From: Claire Booth
Sent: 16 November 2012 10:26
To: Jane Tucker
Subject: FW: Consultation on planning application 3/2012/0899 6 Stoneygate, Knowle Green

From: Hornby, Mark [mailto:Mark.Hornby@lancashire.gov.uk]
Sent: 15 November 2012 15:24
To: Claire Booth
Cc: ENV EPP Customer Service Area East
Subject: FW: Consultation on planning application 3/2012/0899 6 Stoneygate, Knowle Green

I have no objection to this proposal, subject to the following conditions:

Title: Block Plan of Proposed layout
site at 6 Stoneygate lane,
Ribchester

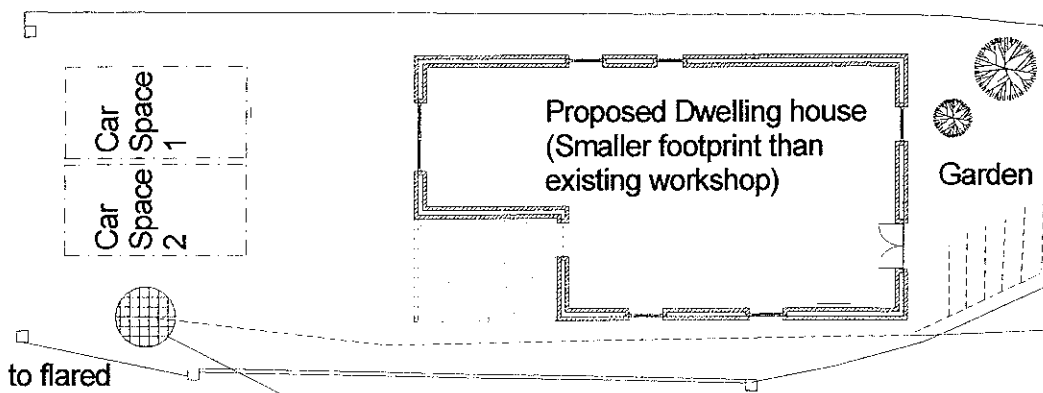
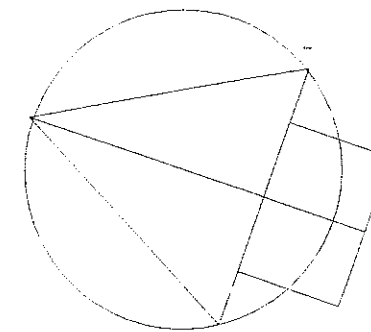
1. The access to the proposed development shall remain ungated. Reason: To permit vehicles to pull clear of the carriageway when entering the site.
2. The vehicular parking area shall be laid out as detailed on the submitted plans and be available for use before the development is brought into use. Reason: Vehicles reversing to and from the highway are a hazard to other road users.
3. Before the access is used for vehicular purposes, the proposed access driveway and parking area detailed on the submitted plans shall be appropriately paved in tarmacadam, concrete, block pavements, or other approved materials. Reason: To prevent loose surface material from being carried onto the public highway thus causing a potential source of danger to other road users.
